Replacement of 6 No. windows in communal hallway from single glazed in wood frames to double glazed PVCu.

The Swallows St Catherines Road Littlehampton

Thank you for your internet representation made on 10th October 2019 which has been recorded as '**an objection**' with the comments as follows:

FLATS 1 - 6 EXISTING WINDOWS

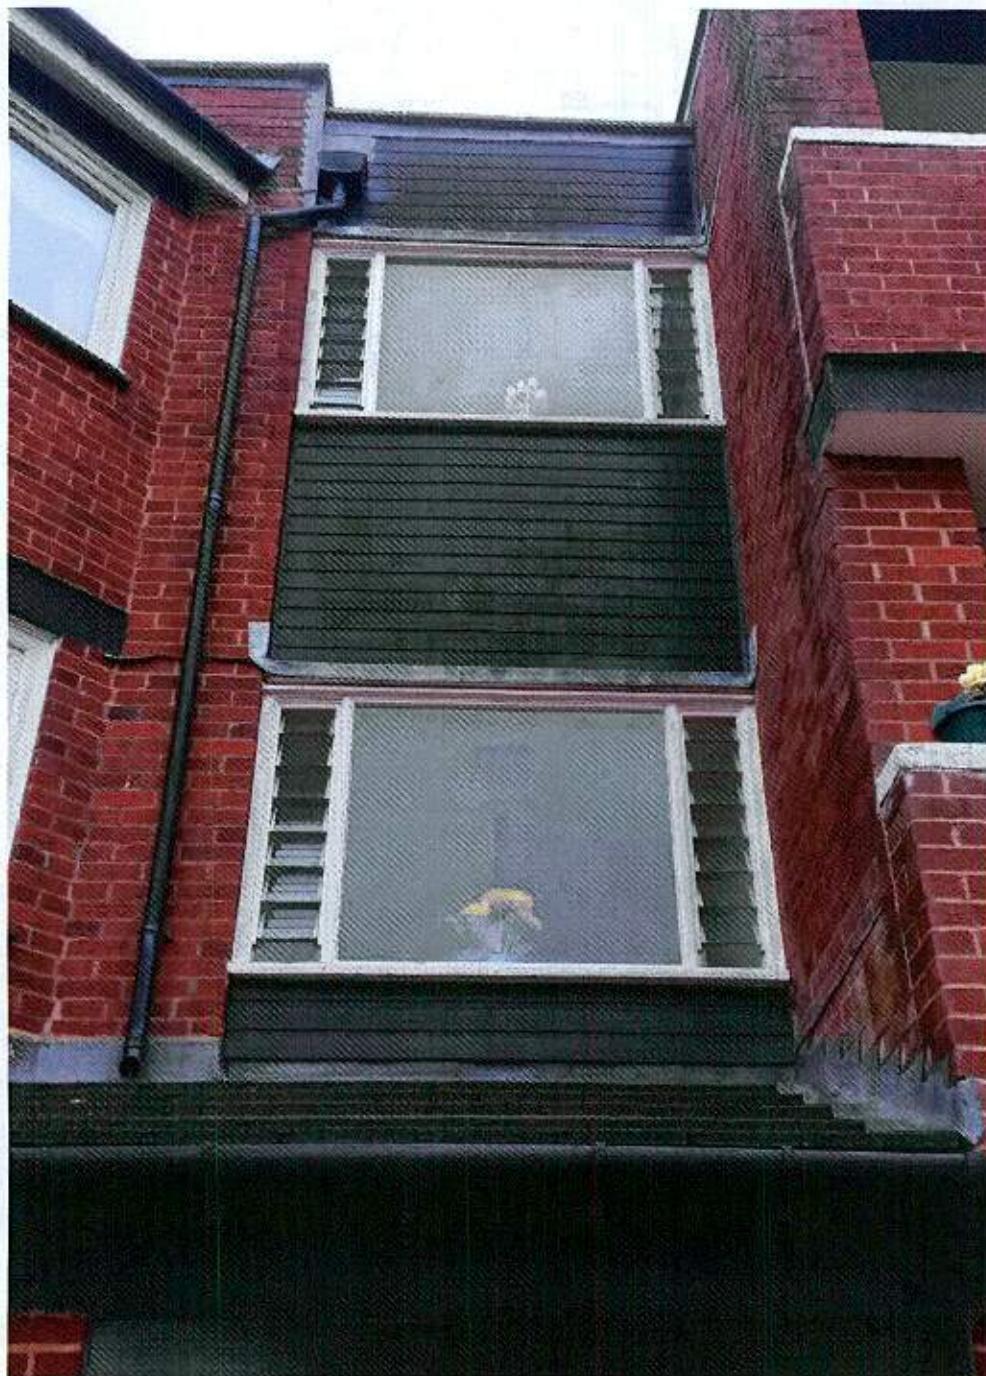
'The Littlehampton Heritage Group wish to submit an objection based on the proposed design of the replacement of the six hallway windows.'

One of the reasons for this in our view is the large panes of glass which characterise the building frontage, rather than the proposed busy PVC units, which contain several panes and frames breaking up the effect.

We consider that the current design of the windows complements, not just the design of the overall building, but the open and spacious character of the area which is uncluttered and reflective.'
